Application number: 2025/93355	
What is the application for?:	Erection of 75 residential dwellings with associated landscaping, open space, hi
Address of the site or building:	Land off, Woodward Court, Mirfield, WF14 0PY
Postcode:	LS15 8ZB

Type of comment: An objection	
Do you wish your comments to be published on the website anonymously?	Yes

TITLE	HEPWORTH LANE / FLASH LANE / SHILLBANK LANE EXISTING HIGHWAY LAYOUT
REF	FIGURE 11
SCALE	1:200 @ A3

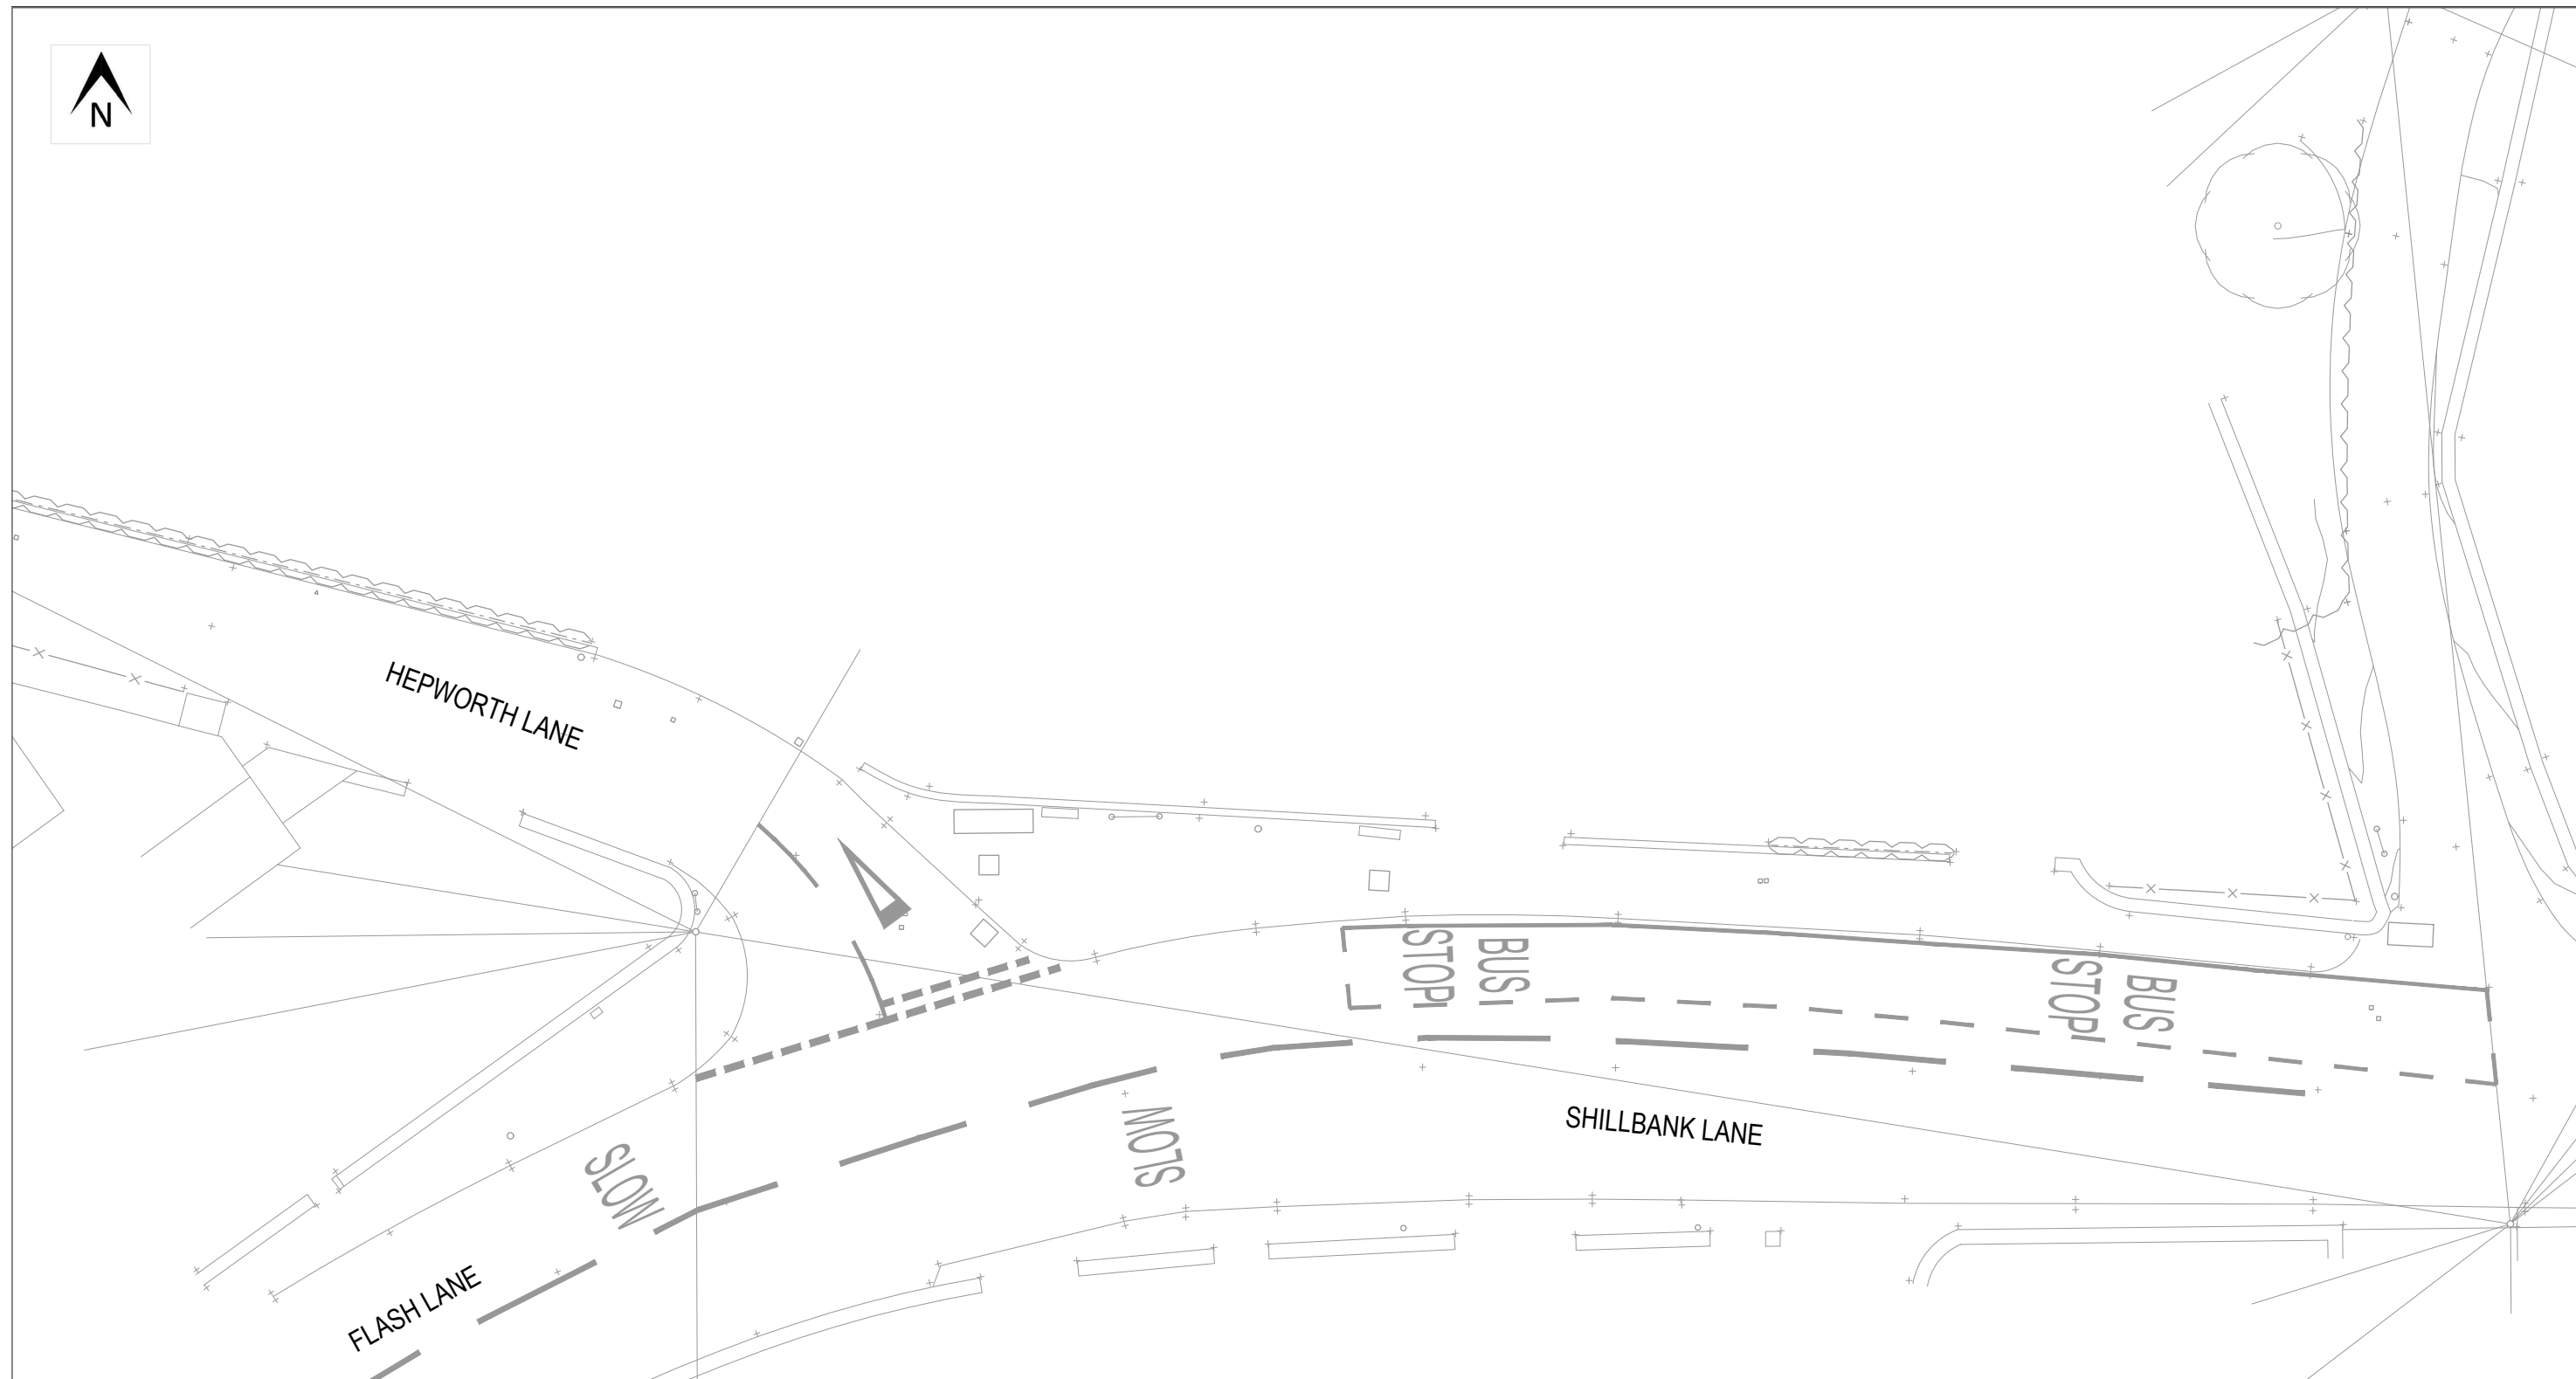
This objection is against the plan to degrade the health and safety and well being of current residents and users of Hepworth Lane. In particular the final 150+ yds at the east end of the lane. We call this the HEPWORTH CORRIDOR.

This is a walled lane less than 4mts wide with no footpaths or road markings. Vehicle and pedestrian traffic is two way, there are no mandatory size restriction on vehicles and it is the popular pedestrian school run. It is lined with dwellings with exits directly into the corridor and there is a feeder junction from a development of bungalows favoured by the elderly. The site line from this Hepworth Drive junction is badly limited by the lane walls and width. Exits and entries are precarious.

The corridor is excited and entered from the east and west on the bend at Shillbank Top. Entry from both directions is into the corridor which is a ONE WAY LANE with an ALTERNATING BOTTLENECK.

Entry from the west is via an almost hairpin bend with sight of any traffic movement, vehicle or pedestrian unavailable to the incoming vehicle. Even with a small vehicle the bend forces the vehicle over to the right blocking the corridor exit. This is a cause of much emergency breaking, reversing and shuffling about.

UNBELIEVABLE as it may be BELLWAY are proposing a new junction sited at the entry to the HEPWORTH CORRIDOR to feed in a flow of new through traffic into the corridor. A reckless, thoughtless plan.
